Reference: Tree Protection Guidelines and Response to Corrections

Date: June 7, 2023

Site Address: 9167 SE 64th, Mercer Island 98040

Parcel: 3024059213 (West Lot)

BUILDING PAD DIAGRAM
1" = 50'

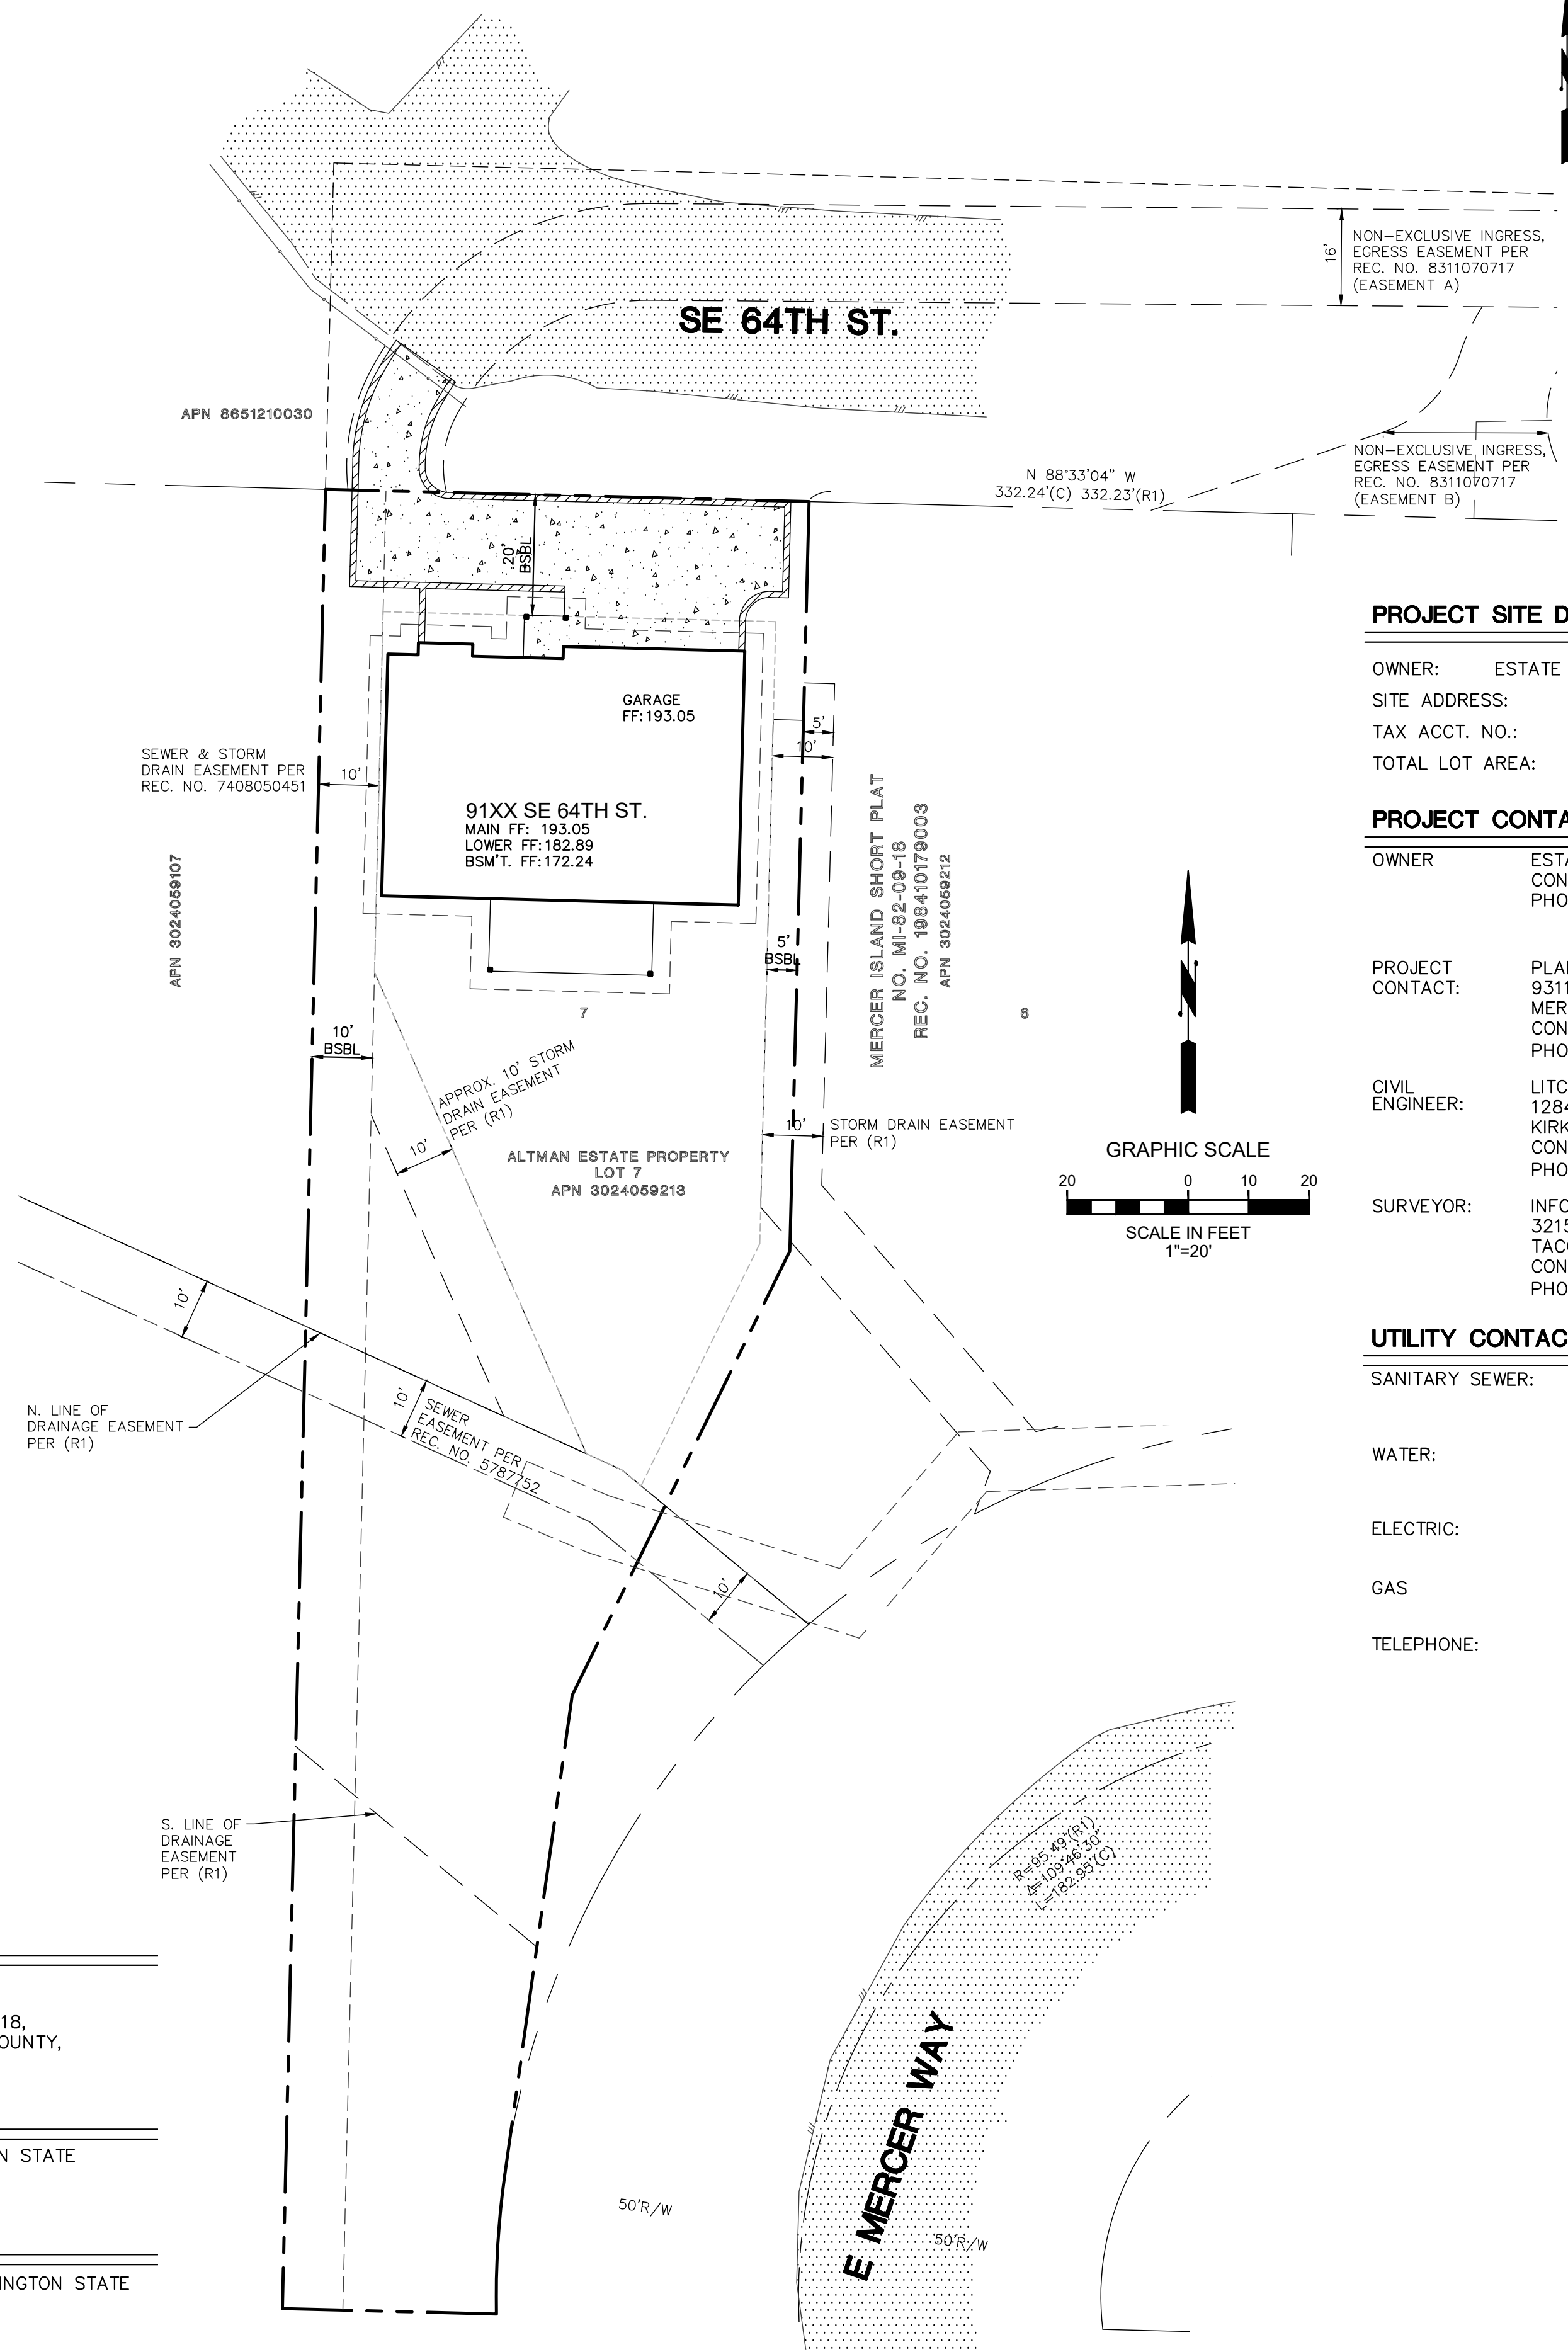
3. (For Civil from intake screening) See checklist for creating a tree protection plan. Show the building pad and all items in the checklist.
"https://www.mercerisland.gov/sites/default/files/fileattachments/community_planning_amp_development/page/21988/treessubmittalchecklist.pdf" [treessubmittalchecklist.pdf \(mercerisland.gov\)](https://www.mercerisland.gov/sites/default/files/fileattachments/community_planning_amp_development/page/21988/treessubmittalchecklist.pdf)

Tree Submittal Checklist submitted separately to Mr. Heard.

DRIVEWAY SECTION
LOOKING SOUTHERLY & WESTERLY N.T.S.

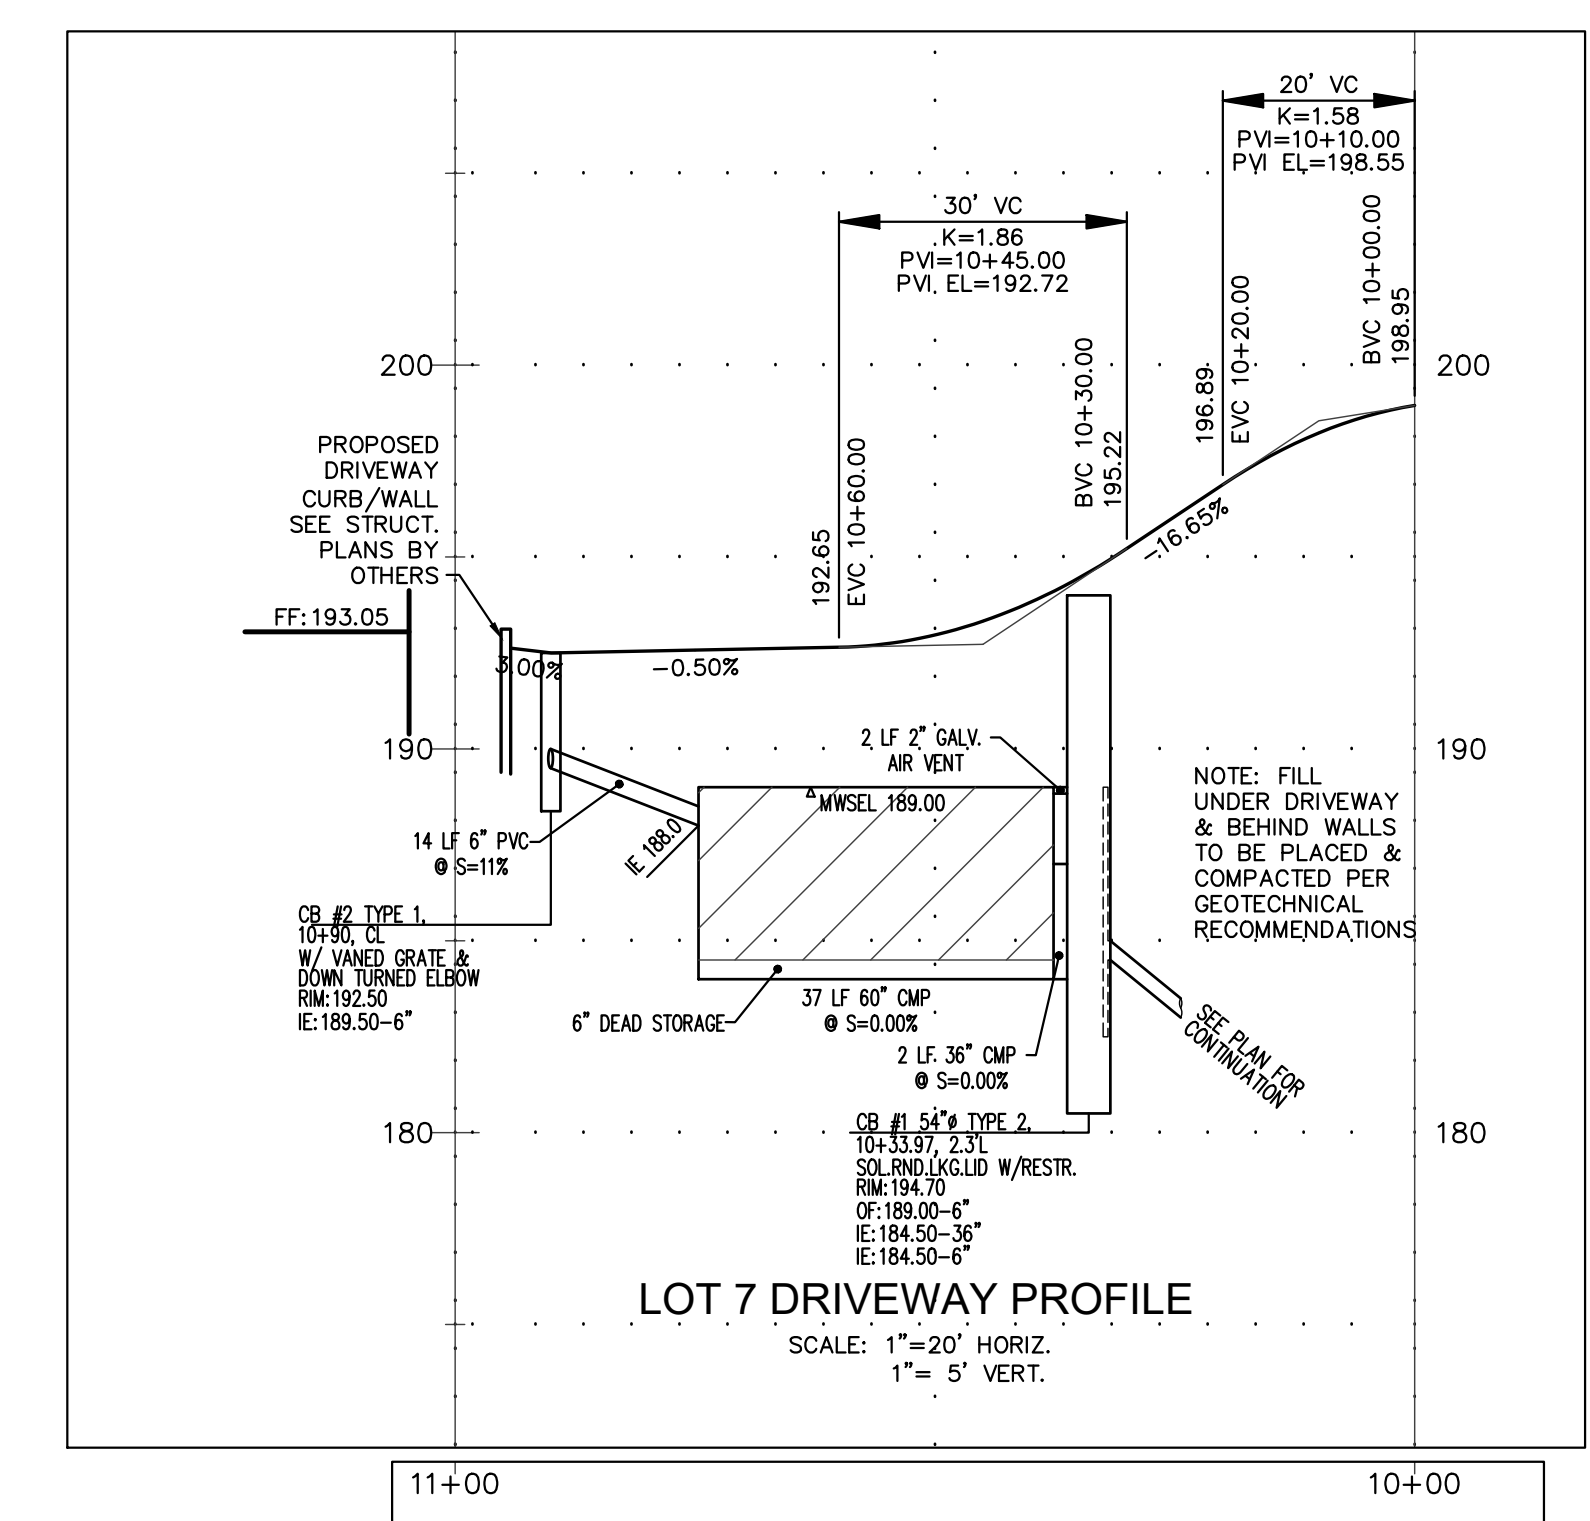
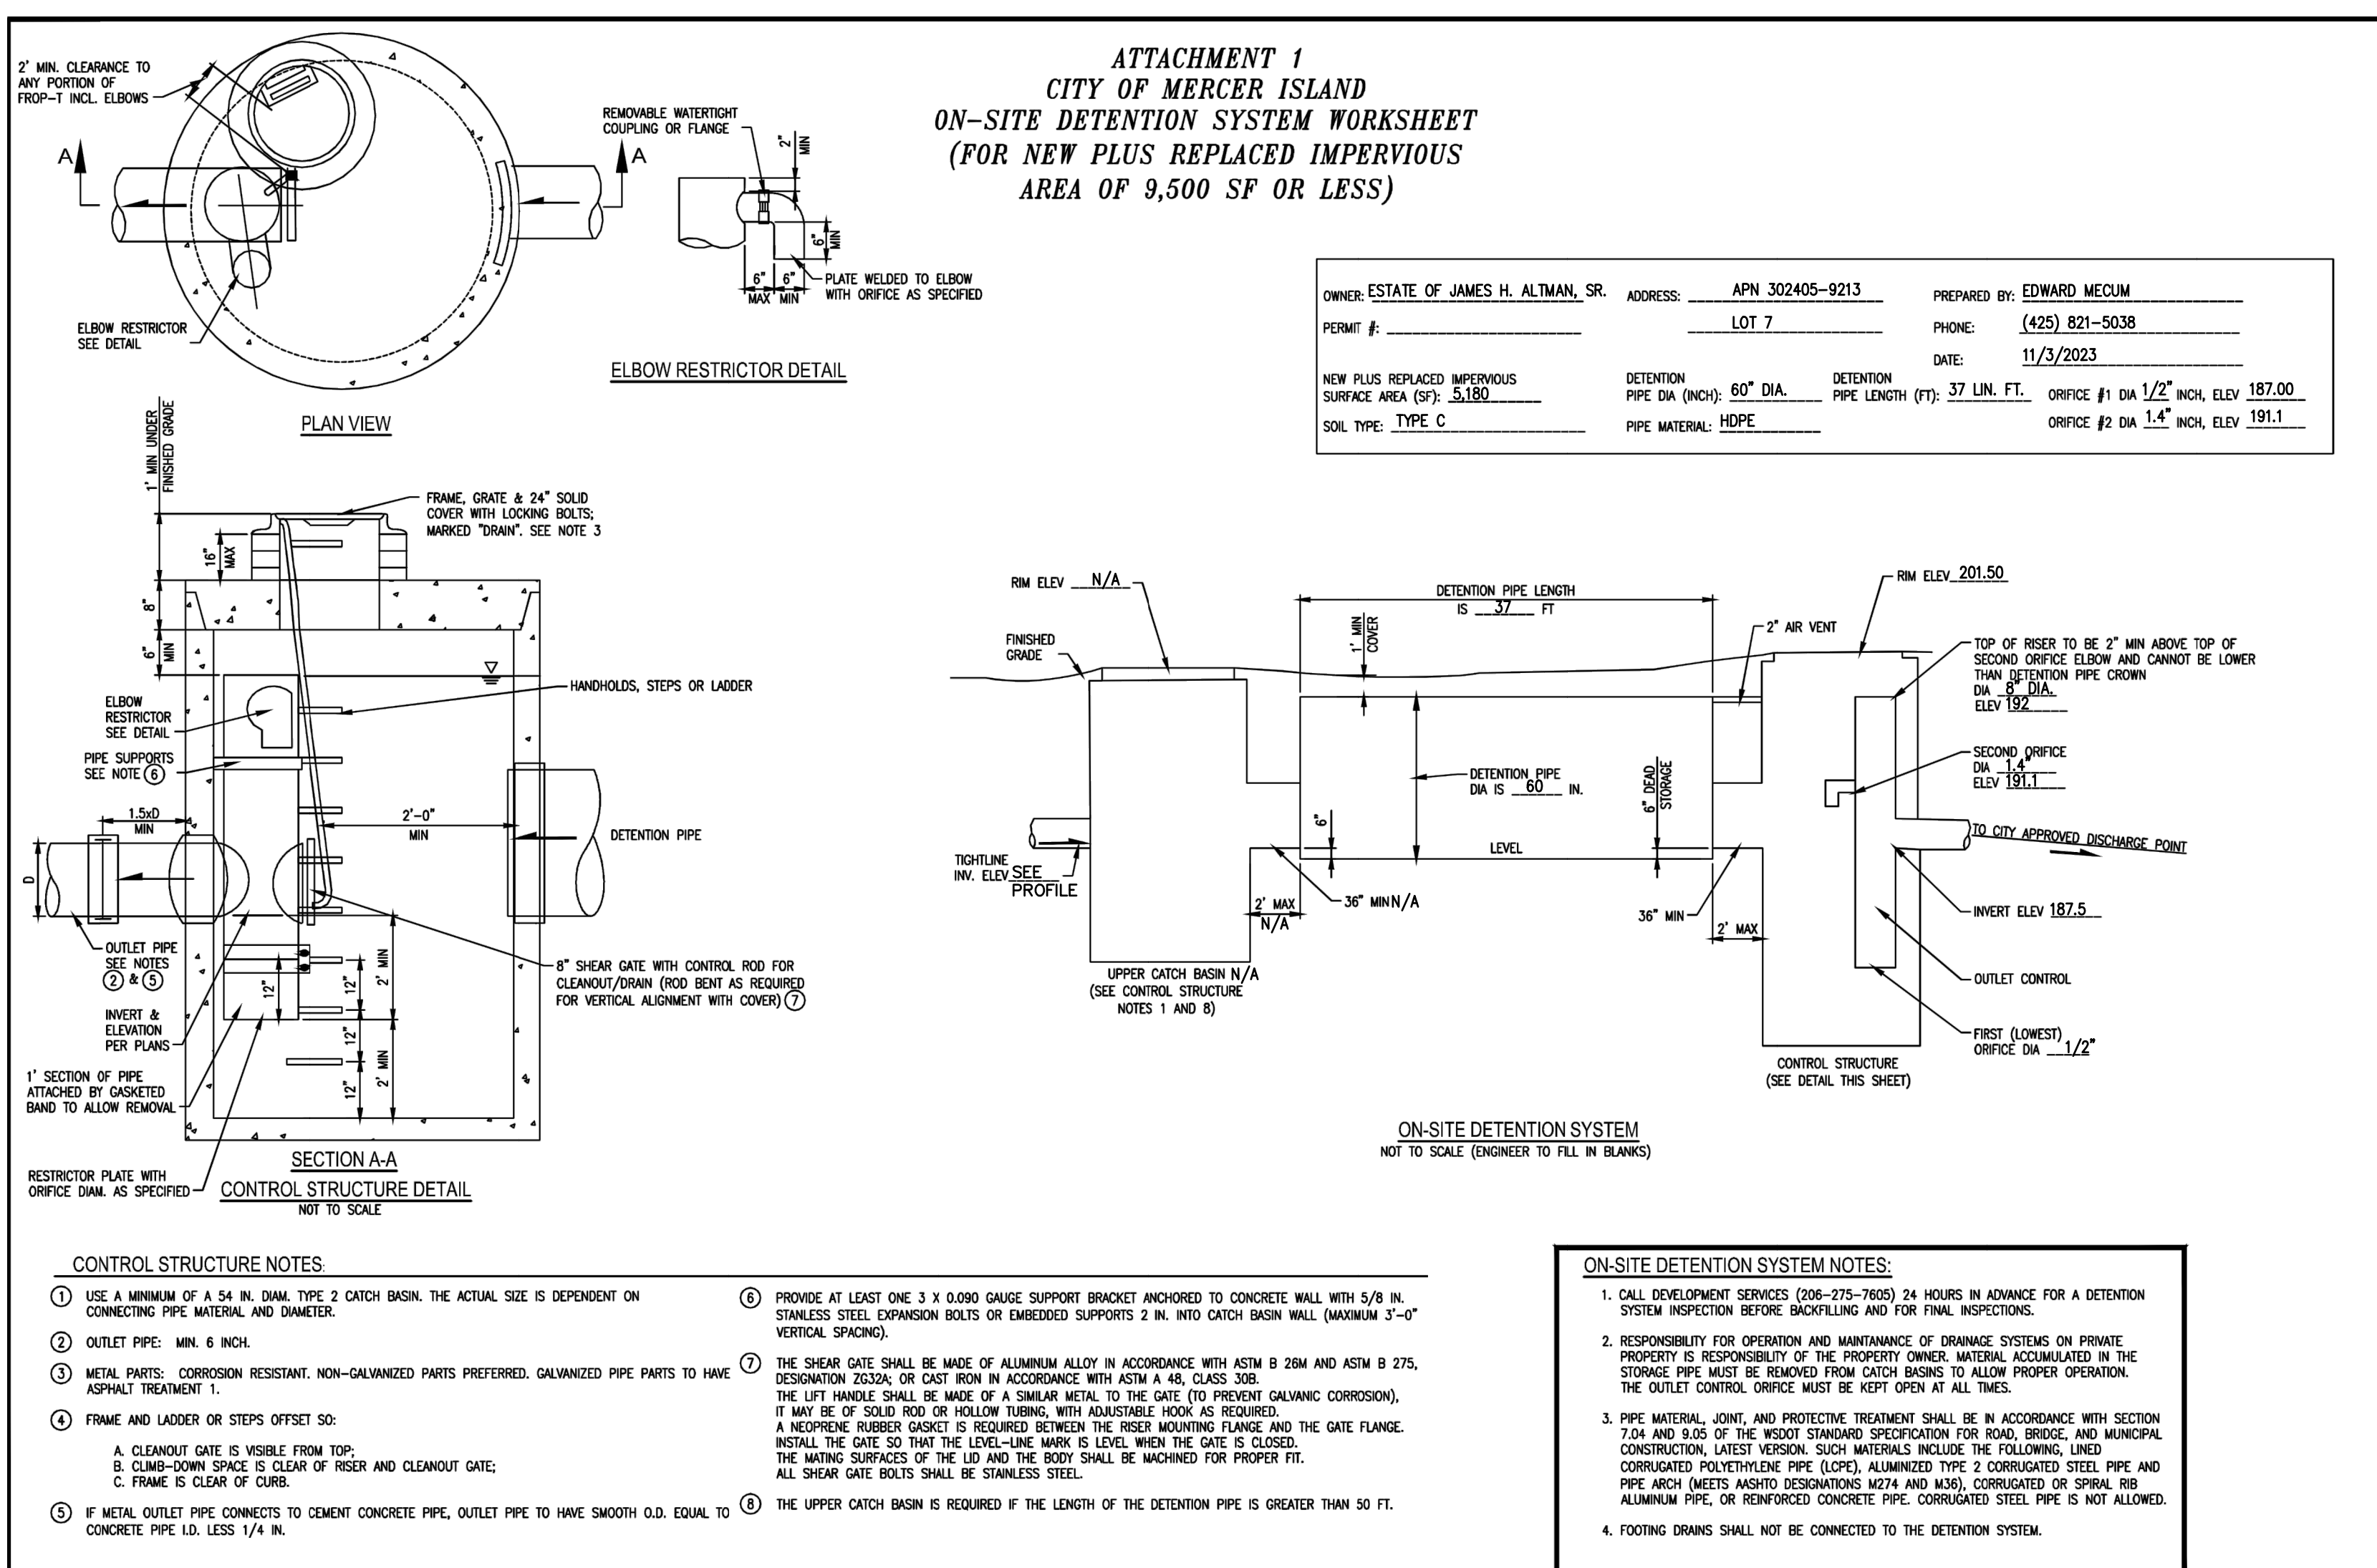
NOTE: Favero Greenforest indicated offsite exceptional trees #3557 and #3557.5 cannot be retained due to grade changes and associated fill. Those trees are currently shown as retained. Please show that these grade changes have been resolved or that

The proposed driveway will be constructed within the LOAD of offsite trees 3557 and 3557.5, two very large cottonwoods. The proposed encroachment is fill over the tree's rootplates from 6 to 7 feet above existing grade. See exhibit right for elevations.

Additionally, excavation for the NW corner of the proposed house will occur within a small portion the LOAD and dripline of these trees.

a tree well and/or retained will will be installed to protect those trees. If removal is required, coordination and agreement with the adjacent property owner is required.

If fencing is not allowed in the ROW around Tree #3468, #3557 and #3557.5, a work zone shall be created to protect roots from compaction from potential construction traffic and/or parking – 5/4-inch plywood placed on top of a minimum 6-inch layer of arborists chips. No disturbance is allowed inside tree protection zones. Currently you are indicating driveway construction and grade changes. Utilize tree wells to protect tree roots.
